RESPONSE TO SUBMISSIONS – MOD 10 MP08_0238
1 DENISON STREET, NORTH SYDNEY

We write on behalf of Winten Property Group (Winten) in regard to the Section 4.55(1A) modification application being MOD 10 to Project Approval MP08_0238 relating to construction of a new commercial building at 1 Denison Street, North Sydney (the site).

LEGEND

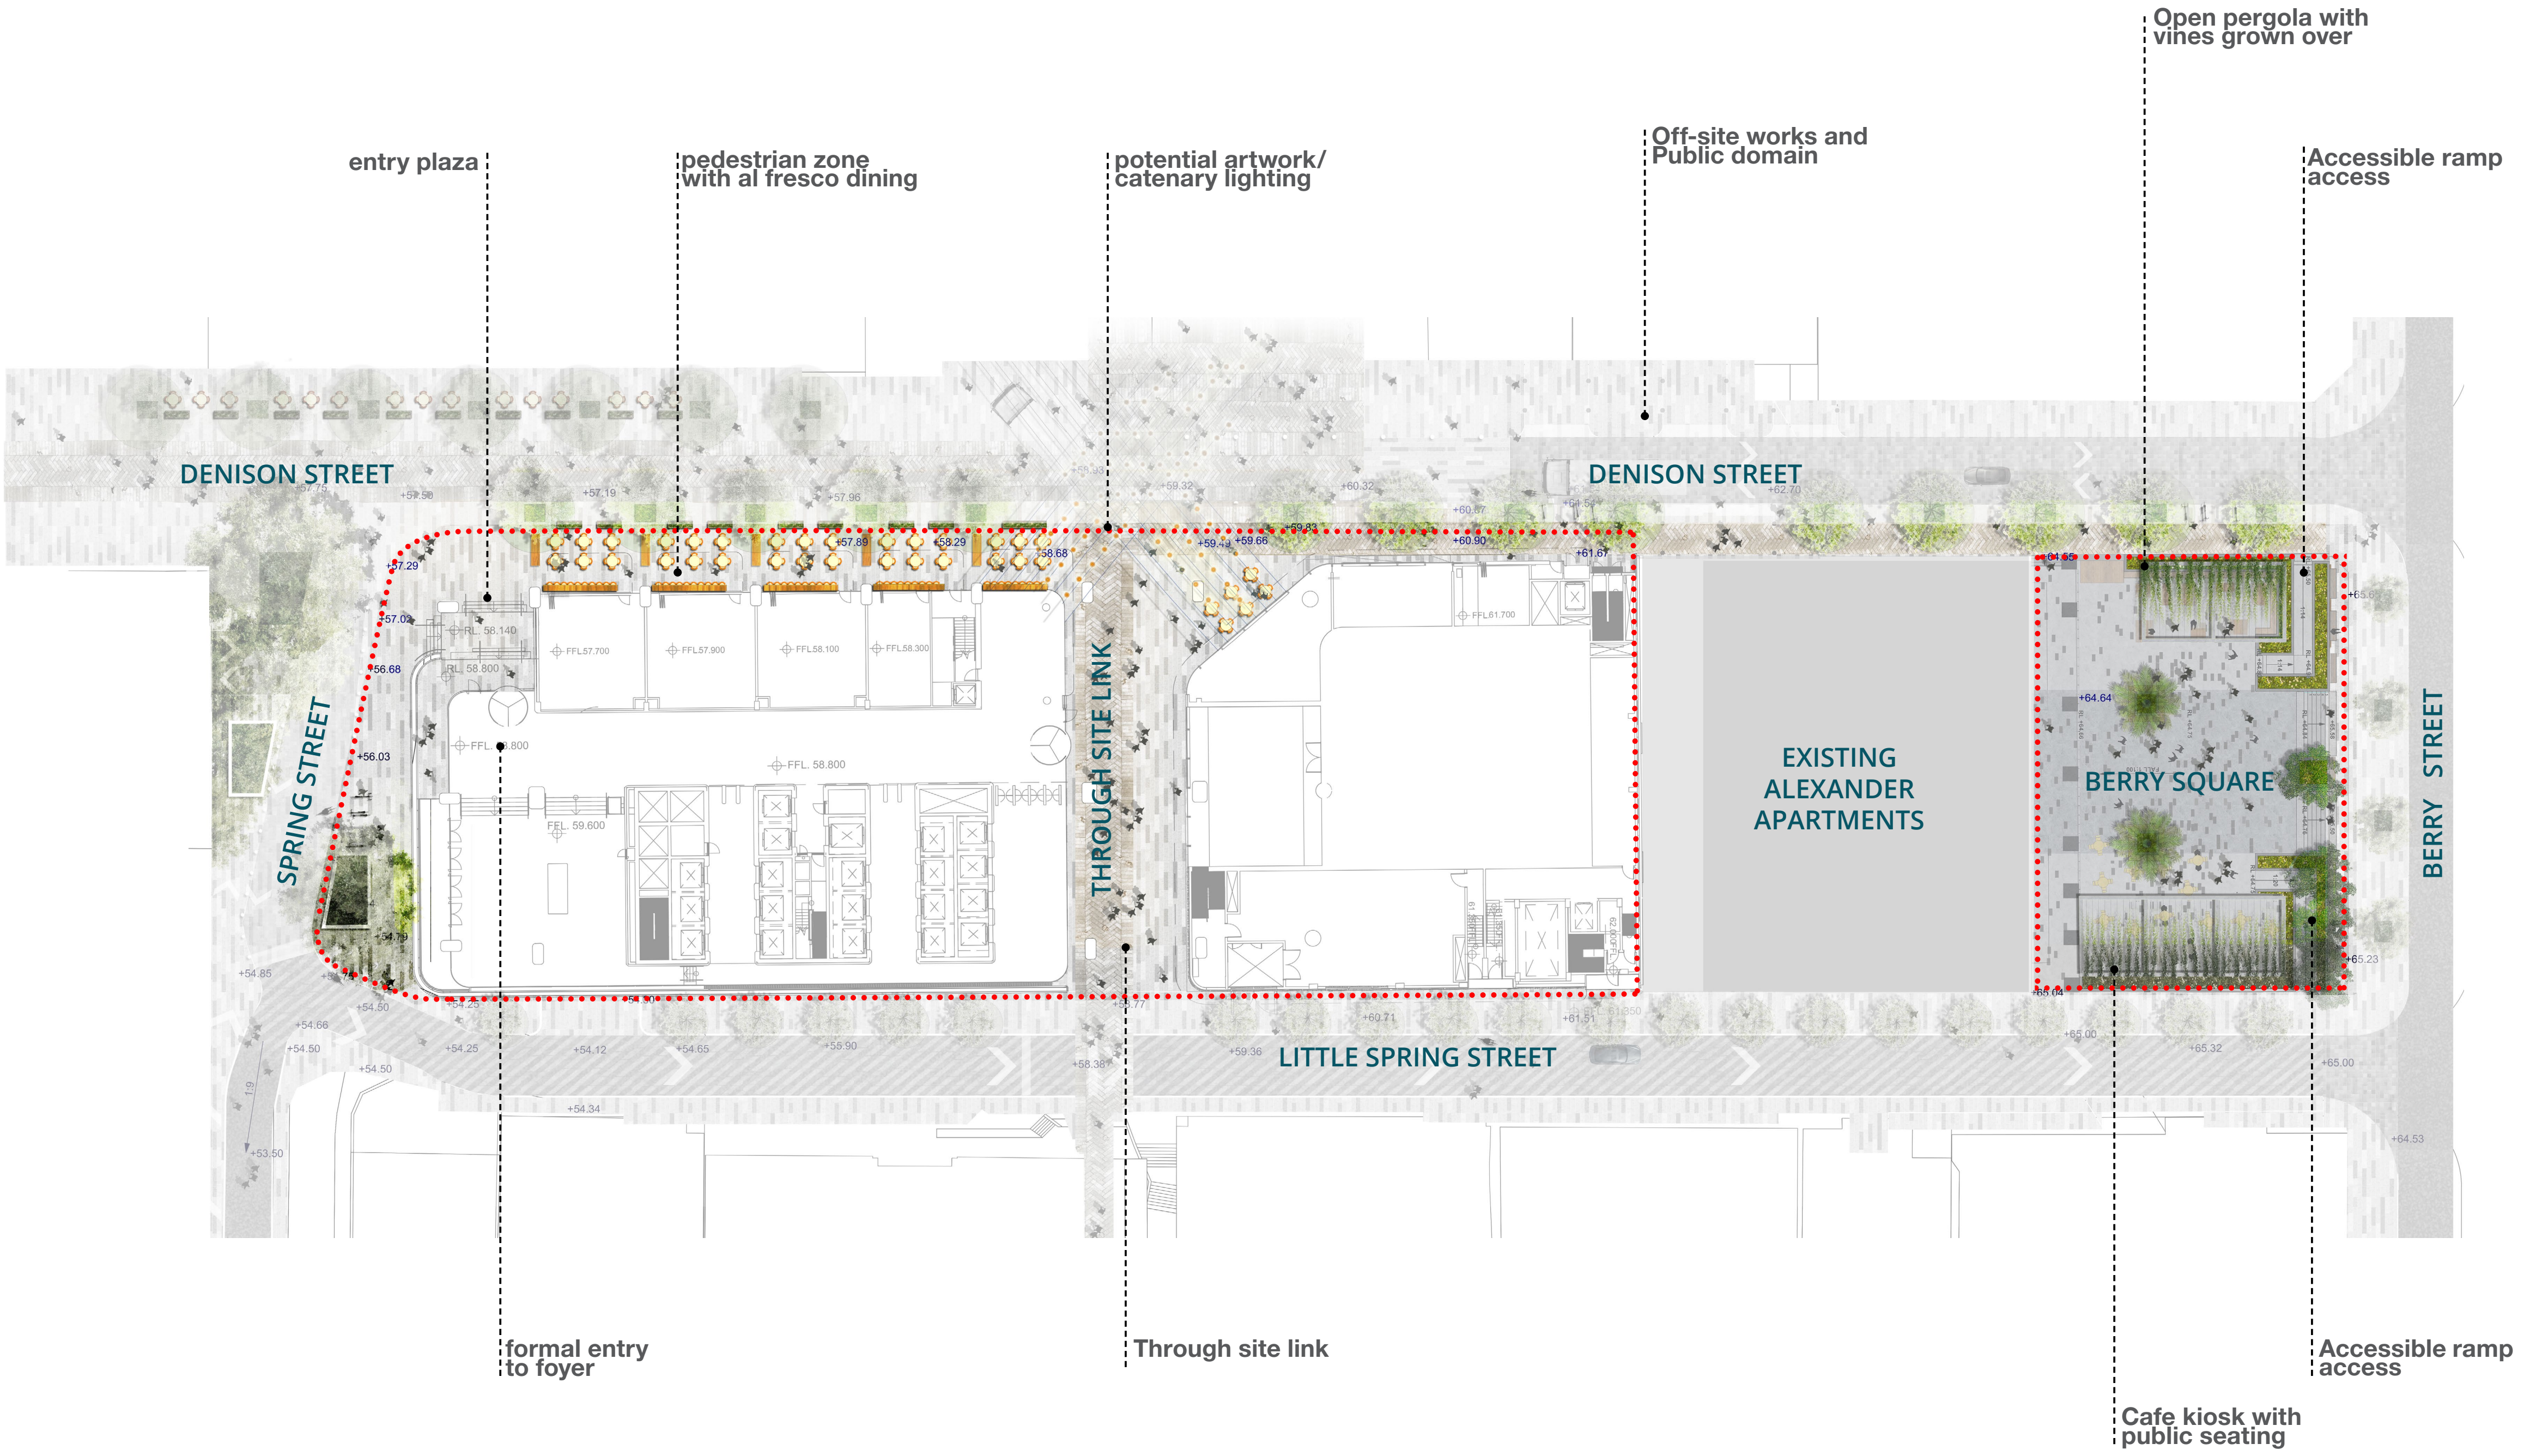
Issue	Response
Council does raised concern with the two electricity substations shown on the Landscaping Plan for Berry Square. These substations were temporary locations during construction at 1 Denison Street to provide power for the construction site and for Beau Monde after the Shopping World building was demolished. Council was advised that the substations would be removed when the substations in the new building were commissioned. This was also an issue for residents of Beau Monde. It is requested that the substations be removed off the plans so that they are not included as part of the approval or that a condition be imposed requiring the substations to be removed prior to the final Occupation Certificate for the proposal.	The Landscape Plans has been amended and submitted at Attachment A . The substations have been removed to reflect Council's concerns and the desired future outcome for Berry Square. We note that the reallocation of the substations is subject to a separate planning process requiring agreement with Ausgrid as the owner and operator of the infrastructure. This process is independent of MP08_0238 and does not form part of this application. Any future changes to the landscape and public domain plans will be prepared in consultation with, submitted to and approved by North Sydney Council prior to the relevant Construction Certificate in accordance with Condition B38 Public Domain and Landscaping.

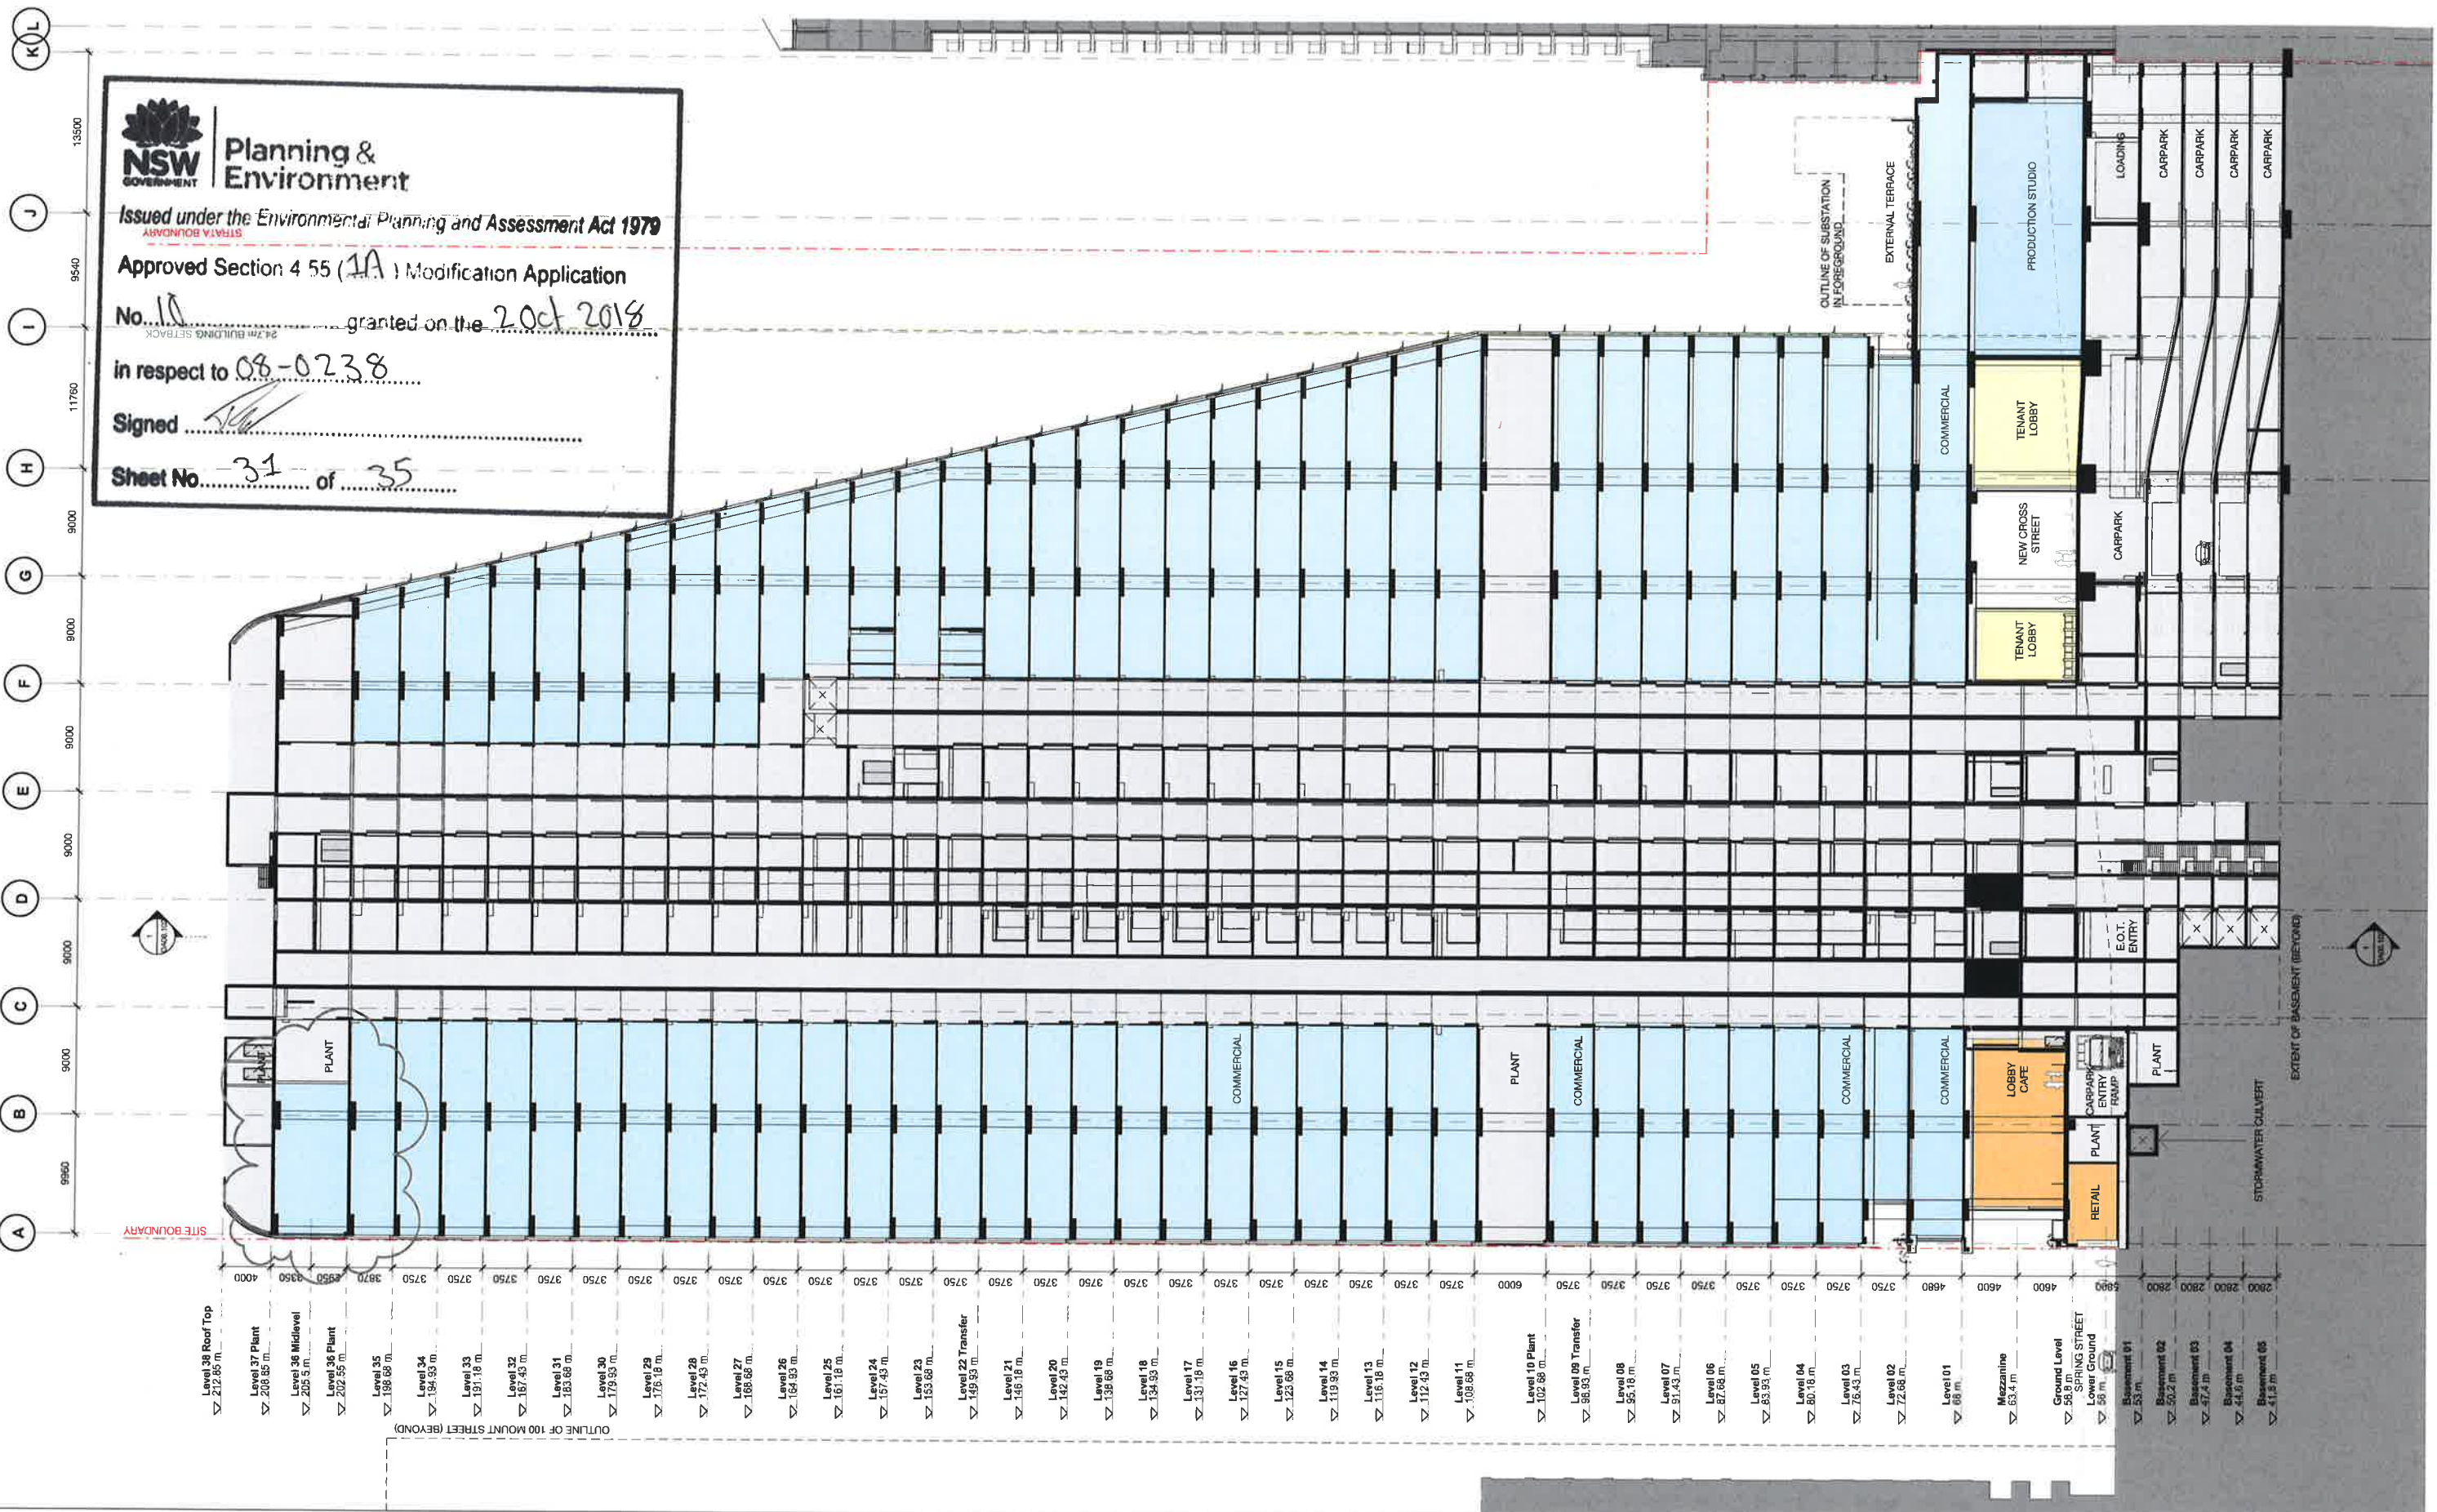
Issue	Response
Council	
Council has no objection to the changes to the building proposed.	Noted.
Council suggests that the lighting of the roof profile might be referred to the Sydney Observatory for comment as concerns have been raised in the past by the Observatory with some roofs signs in the North Sydney CBD.	Refer to the Sydney Observatory section of the table below.
Council raises no objection to the updated landscape design for Berry Square as this has been discussed with Council previously.	Noted.
